APPLICATION NO. 05DRB - 01538	PROJECT NO. 1004138
PROJECT NAME JOURNAL CENTER	
EPC APPLICATION NO.	9700
APPLICANT / AGENT MARK AYUWARD	PHONE NO. 761-4222
ZONE ATLAS PAGE D-17	
(SDP for SUB), (SDP for BP), (FINAL PLATS), (MASTER DEV PLAN), (IR), (AA)	
ONE STOP COMMENT FORM LOG

DRB CASE NO/PROJECT NO: 1004138

**CITY OF ALBUQUERQUE
PLANNING DEPARTMENT
May 11, 2005
DRB Comments**

RE: Tract 5, Journal Center/SPBP

0 4 8 **B5** PARTIAL NORTH ELEVATION 1/8" = 1'-0"

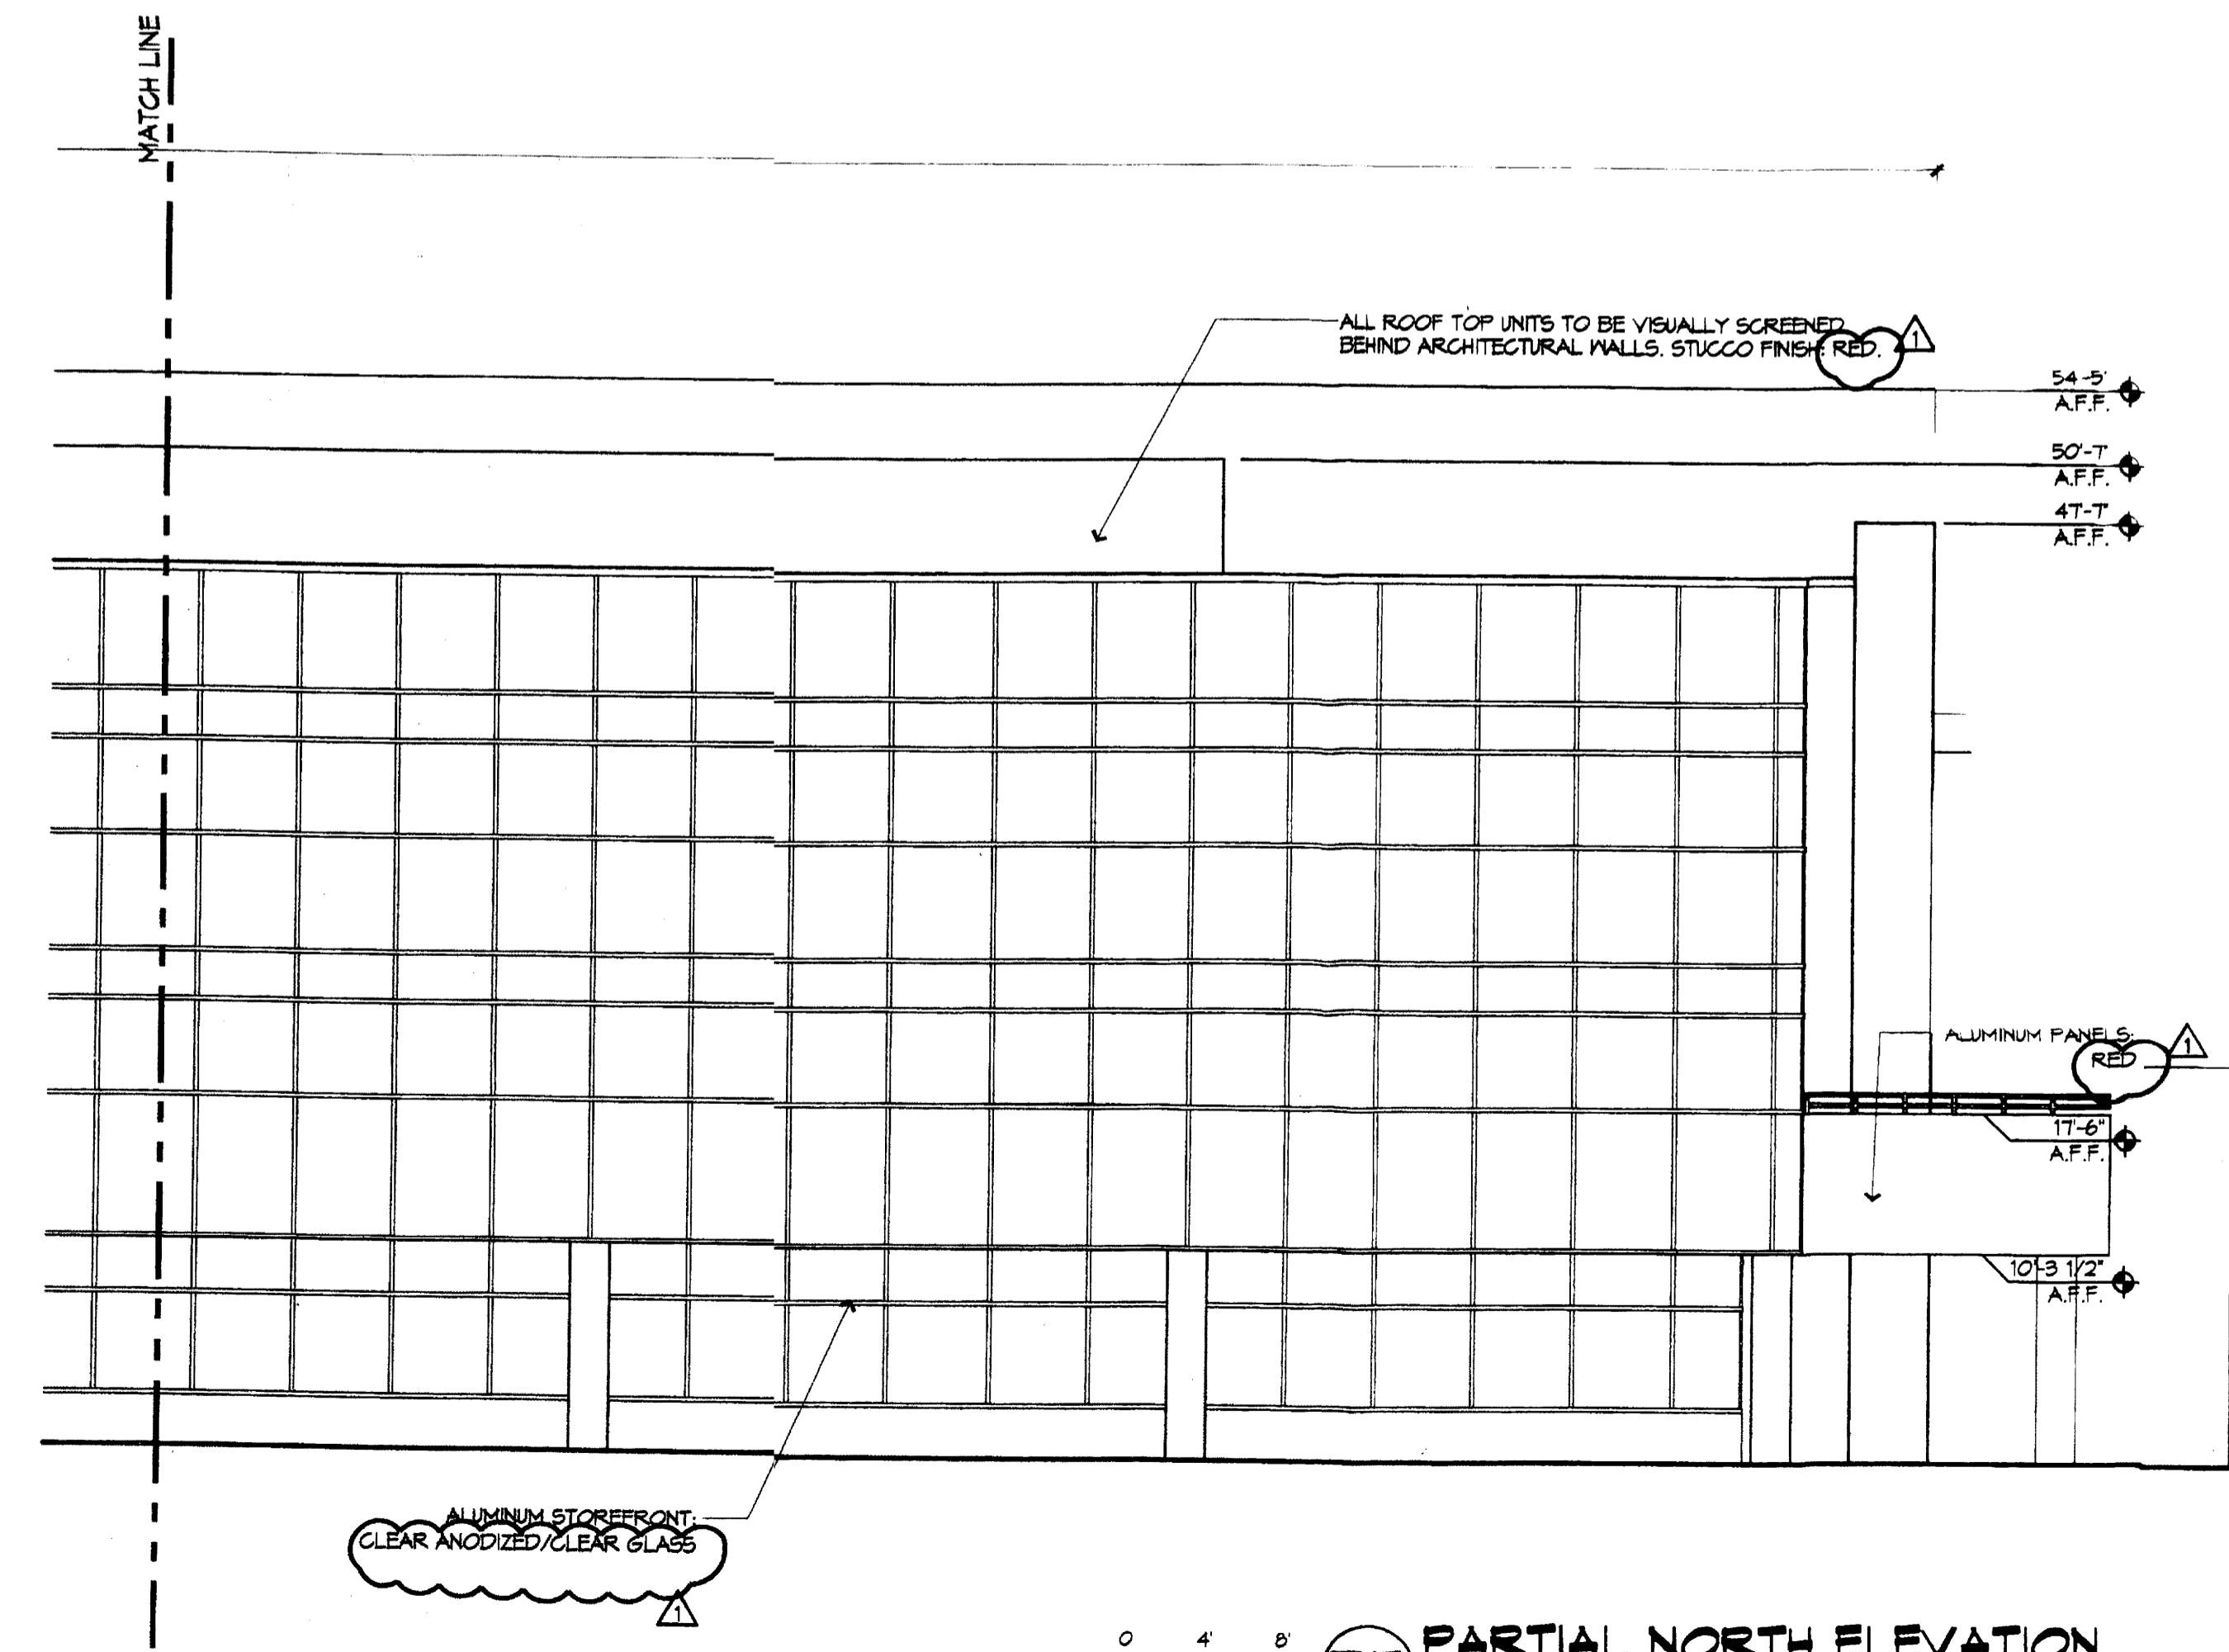
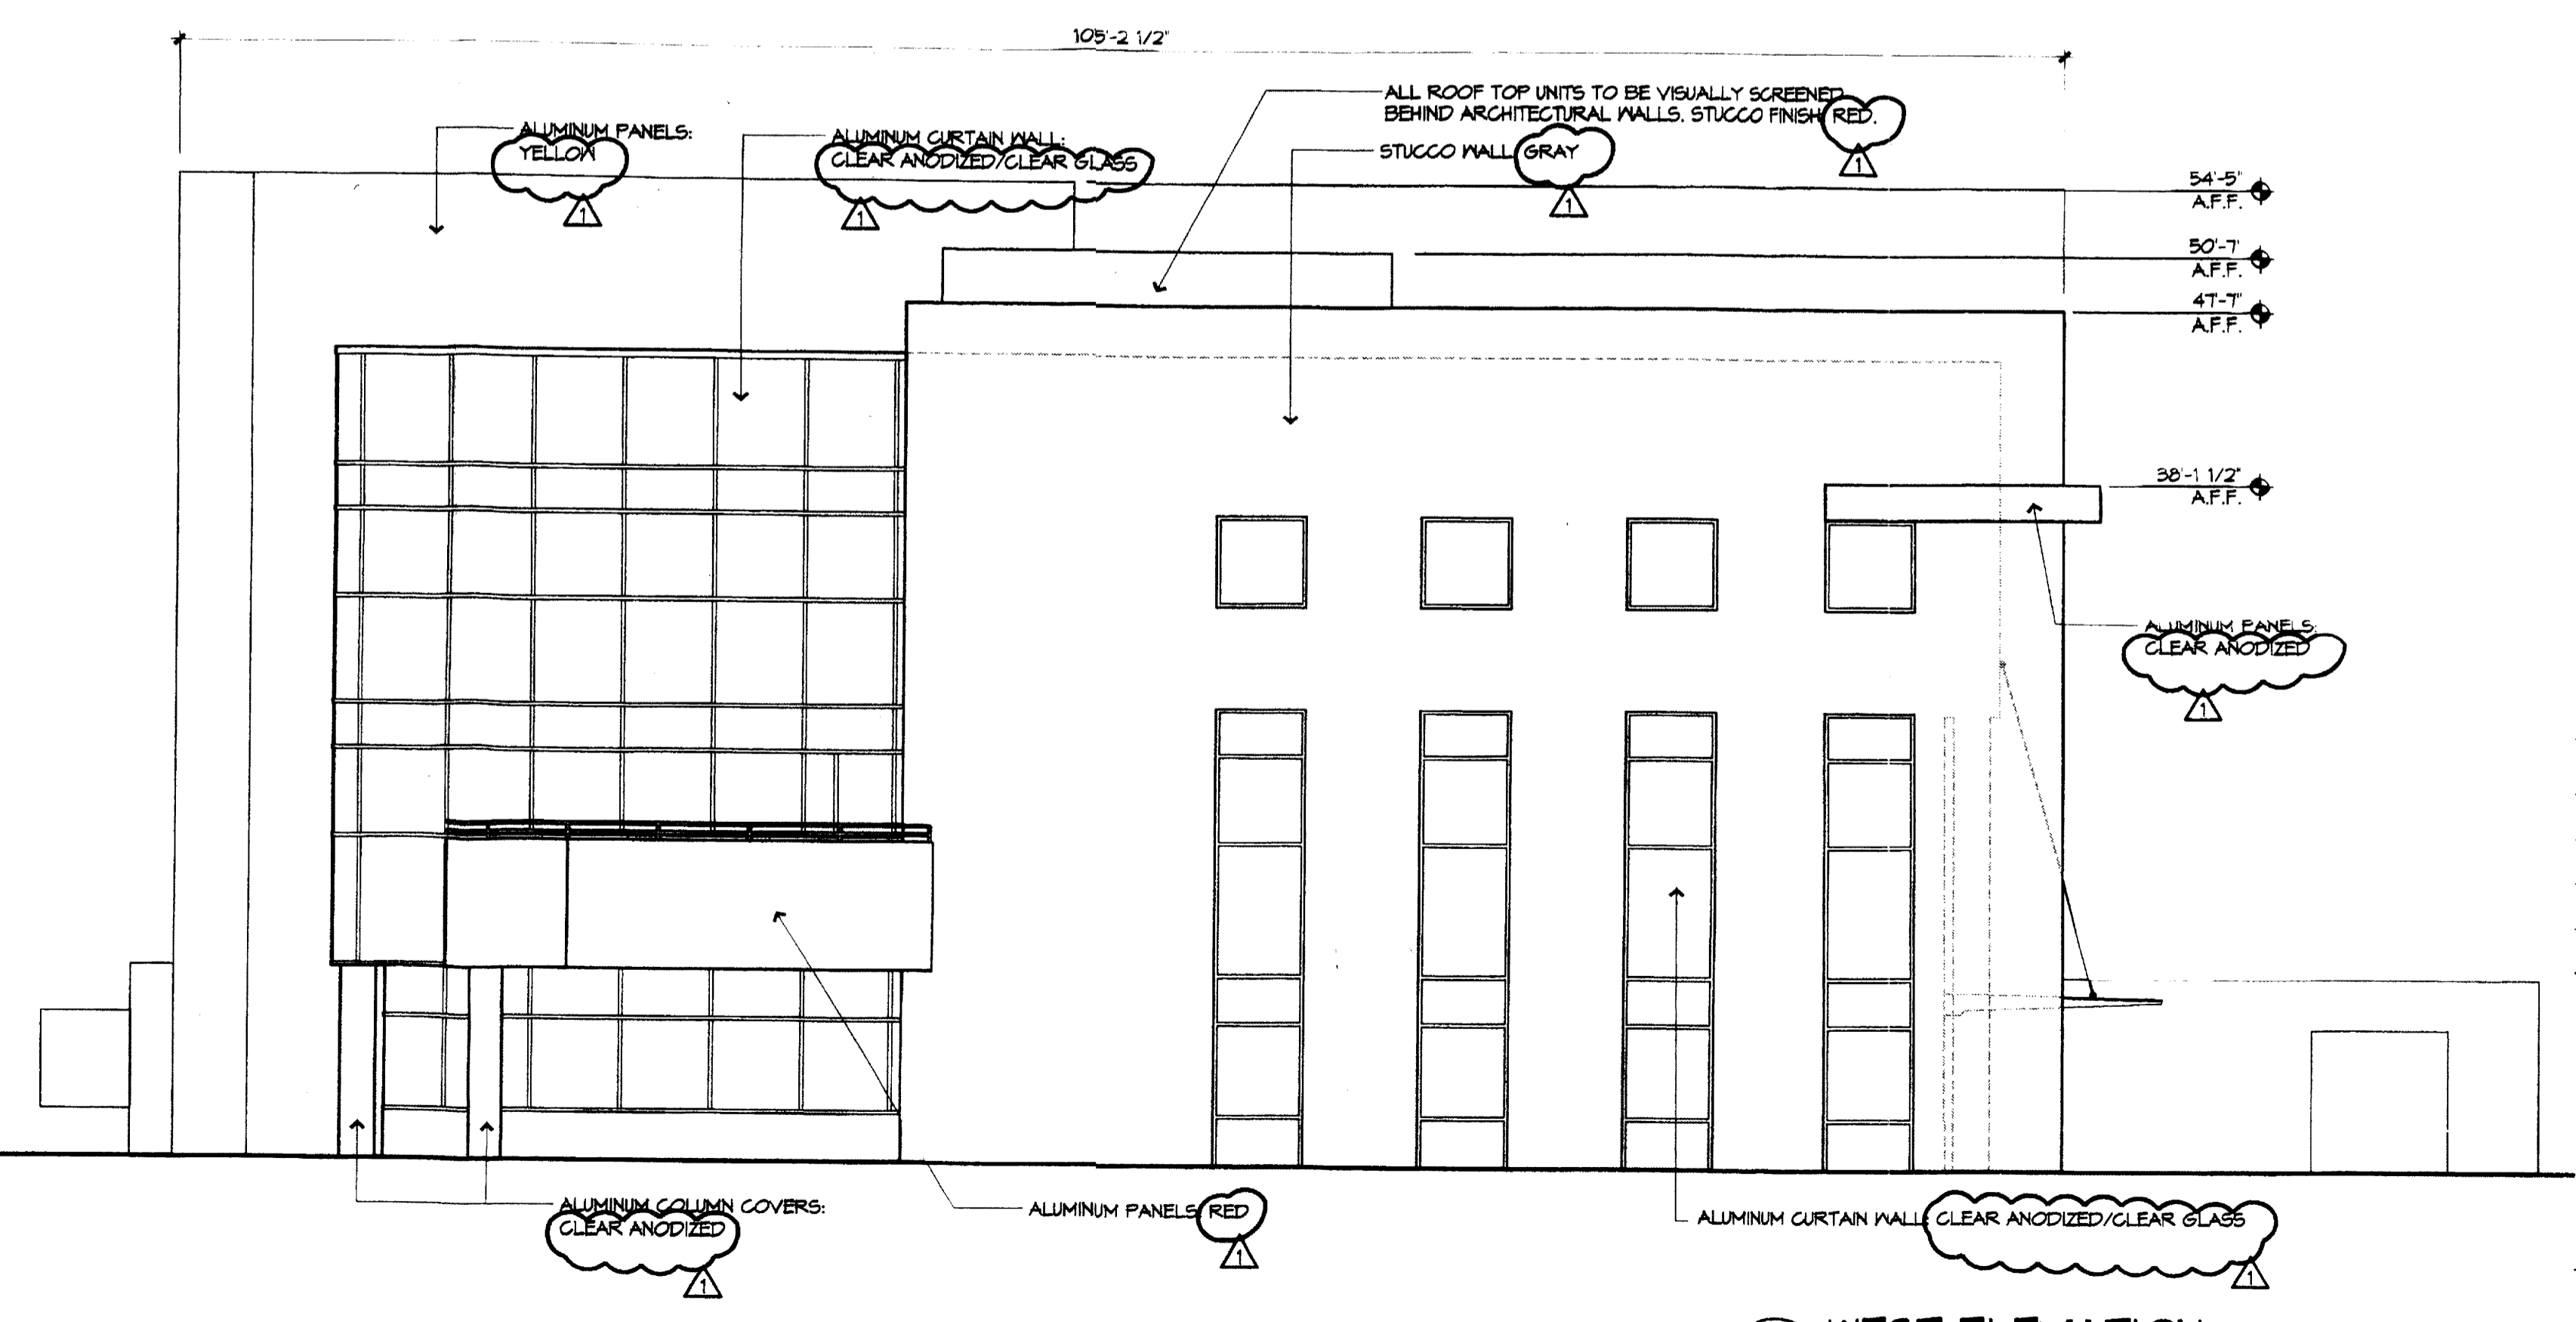
*✓ Who signed for Planning Director?
✓ Total width missing on Elevations
Sheet.*
